From: Nicola Moore
Sent: 22 March 2021 11:00
To: Gail Marsh
Subject: RE: Request for further information AB/33/21/CLP

BASEMENT LAYOUT / A3

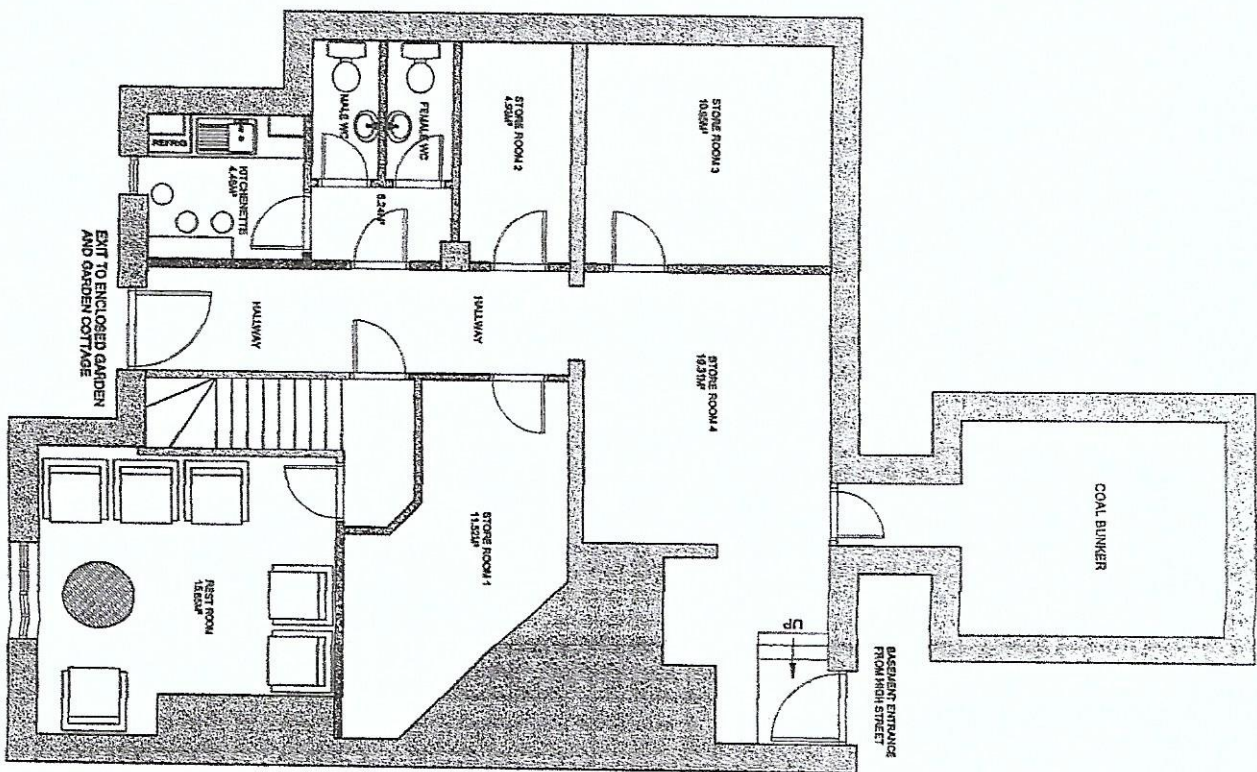
With reference to your email below, please can you remove the scale bar and scale on the floor plans as they are not to scale. This will then be sufficient. With regards to the elevations, if you are unable to get a plan, a photograph will be sufficient. The photo should be submitted as a PDF.
